Martin Nugent
01254 828060
D3/12/0219

Drafted 12 April 2012

**Planning Application, Ribble Valley District
D3-12-0219 Altham Pumping Station, Burnley Road, Simonstone**

Drawing Number  
TRI-0815-02

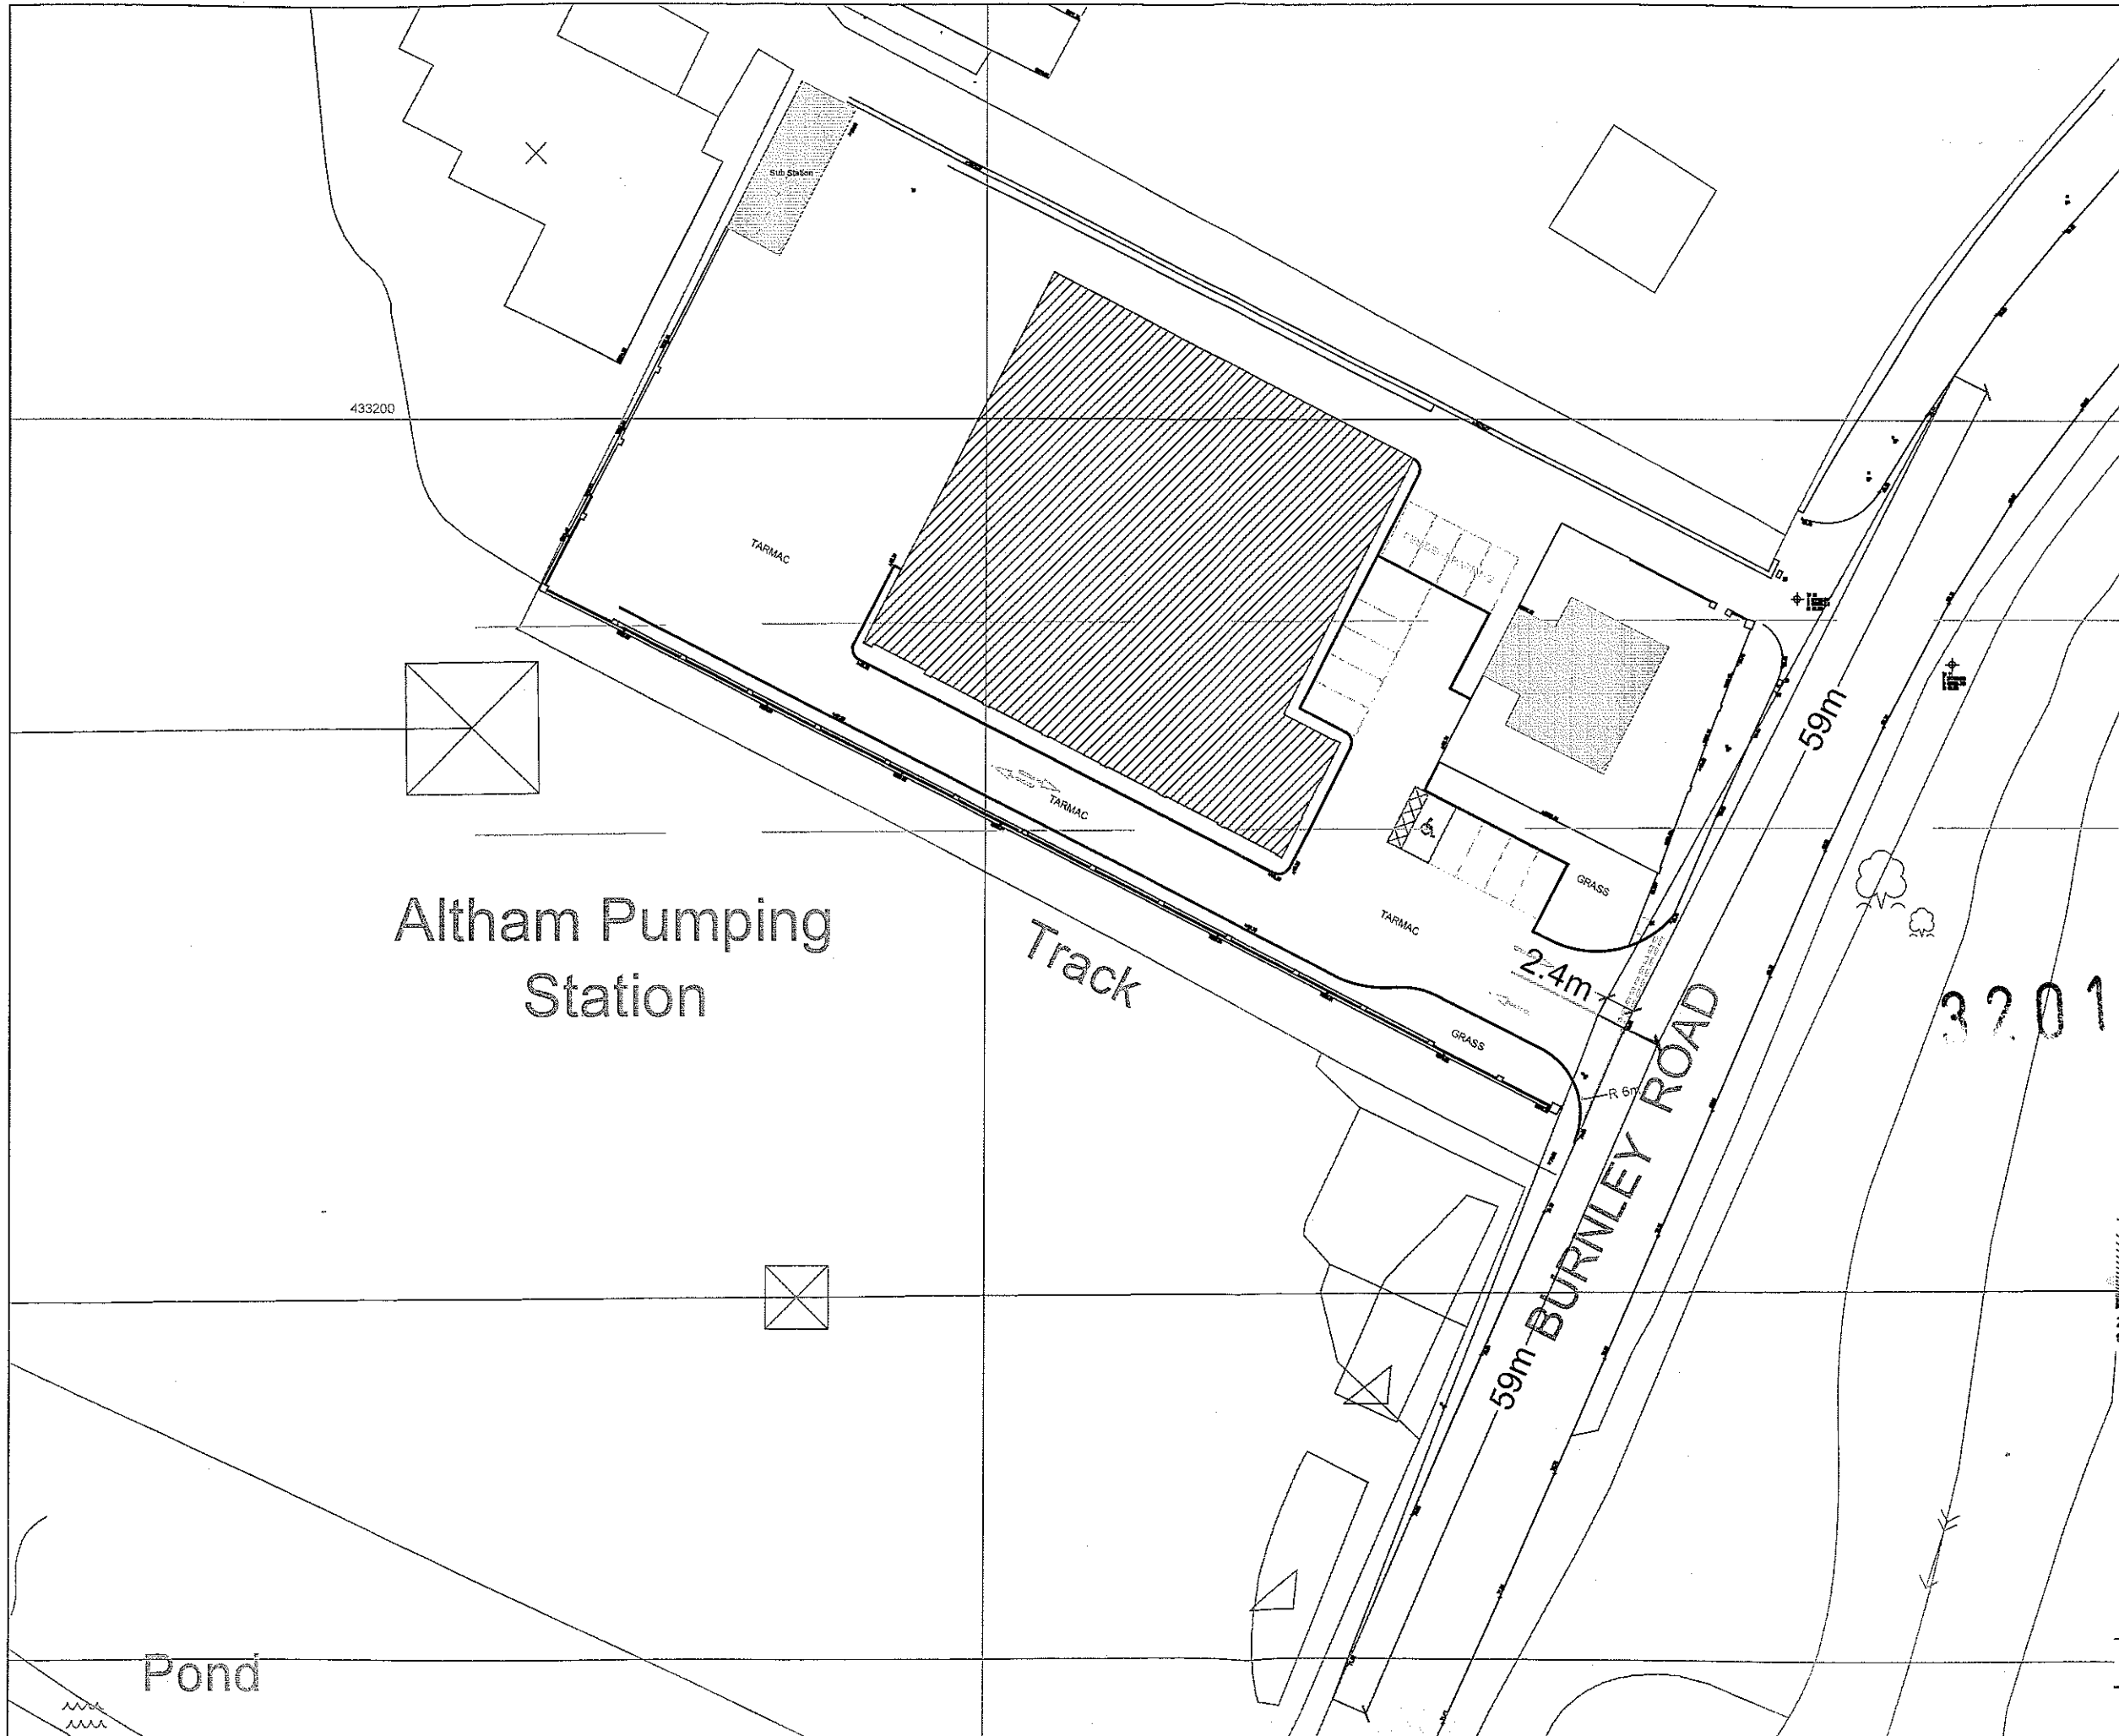
The layout shown on the site plan, Drawing TRI-815-04, indicates parking provision for 10 cars, including 1 mobility space for the commercial premises, while another 4 spaces are shown for residential use. The level of provision and the accessibility of these spaces are satisfactory.
